From: [James Neave](#)
To: [Rampion Offshore Wind Farm](#)
Cc: [Dawn White](#); [Ami Dye](#); [Katie Kam](#); [Nicholas Scott](#); [Neil Vigar](#); eleri.wilce@rwe.com
Subject: NMC - Rampion Offshore Wind Farm Order 2014 - EN010032 - WSCC Comment 25 11 20
Date: 25 November 2020 09:04:26

Further to the attached consultation received in respect of the above, in principle, West Sussex County Council (WSCC) does not raise any concerns regarding the proposed PROW re-alignment as shown. This largely reflects the more sinuous route already agreed as part of the various requirement schemes (in particular requirements 11 and 15) for the substation site - [Stage 1 documentation](#).

Footpath diversion consented under The
Rampion Offshore Wind Farm Order 2014

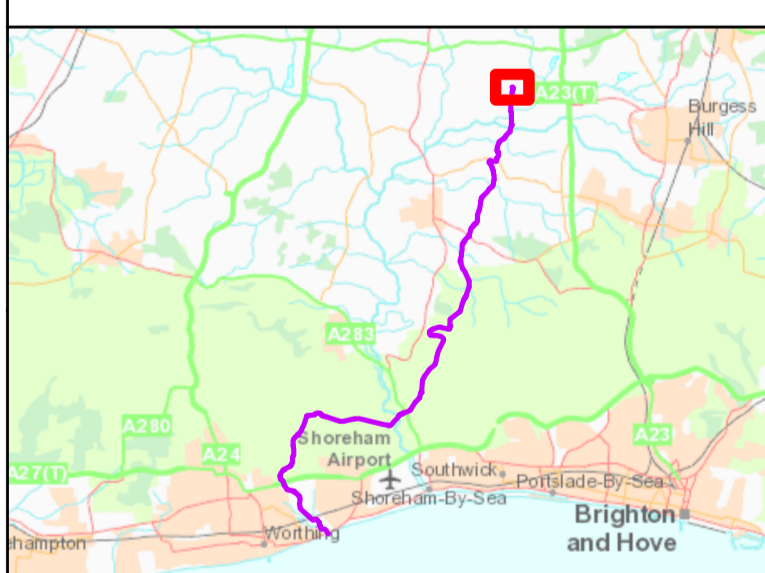
As noted, WSCC do not consider a formal deed of dedication for the new footpath is required as Article 17 of the 2014 Order (as amended) is sufficient to dedicate the revised footpath route as a public right of way.
